Application number: 2019/91980	
What is the application for?:	Erection of two storey side extension, front porch and formation of new vehicula
Address of the site or building:	6, Osborne Terrace, Batley, WF17 0LZ
Postcode:	WF17 5NN

BLOCK PLAN
SCALE 1:100

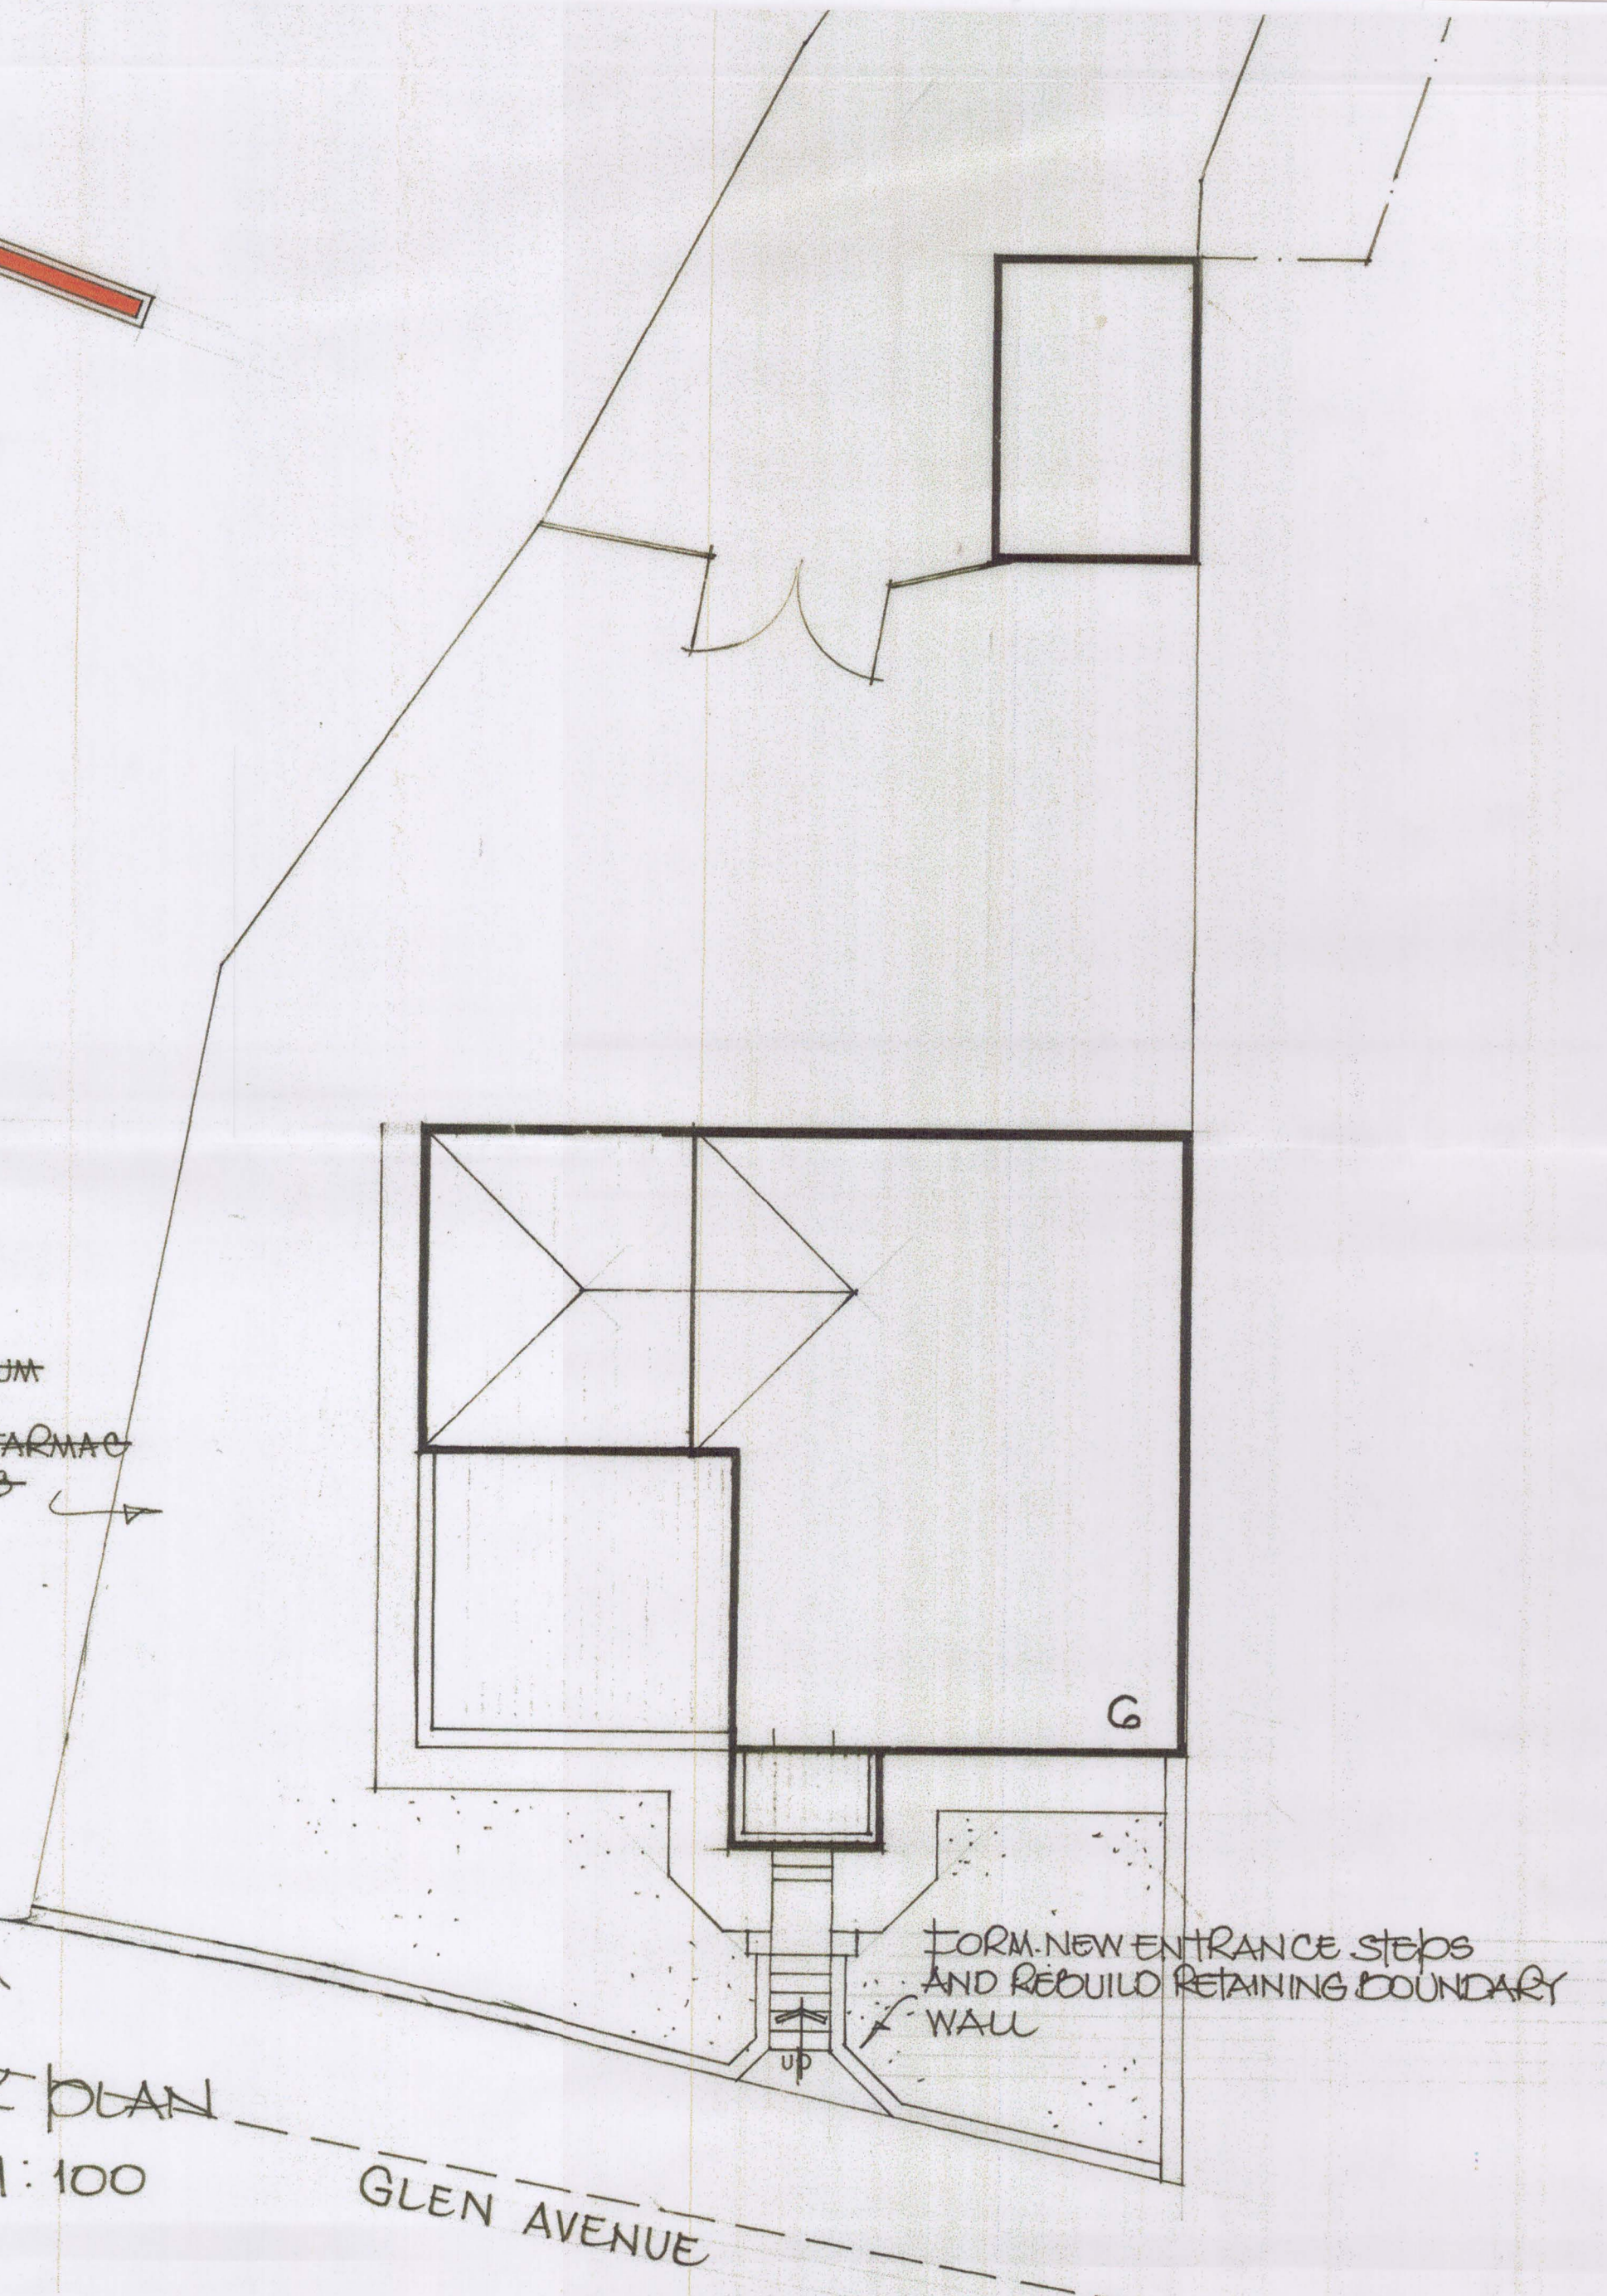
Type of comment: An objection
I wish to object same as my original objection. The planning application has not really changed. This are is already very congested. The Wayne Close road is used as a rat run from York road and surrounding areas. Vehicles pass at such a high speed, wanting to get to the destination without any consideration for the neighbouring vehicles pulling in and out of the drives. At peak times this area is used by parents picking up kids from Batley High School. Vehicles are double parked. Sometimes the children cant even see cars passing up and down the road has a blind spot is created on both sides of the road. I suggest, someone from KC, come and carry out a survey at school times, to see what it is really like, and how dangerous it is, another reversing vehicle on to the main road, is the last thing we want. The proposed extention, will directly look in to our main bedroom, which will invade our privacy, I hope you take this in to consideration. I have no issues with short term distrupction, but this vehicular access, will cause more problems in an area where is it already very congested. Think about child safety!
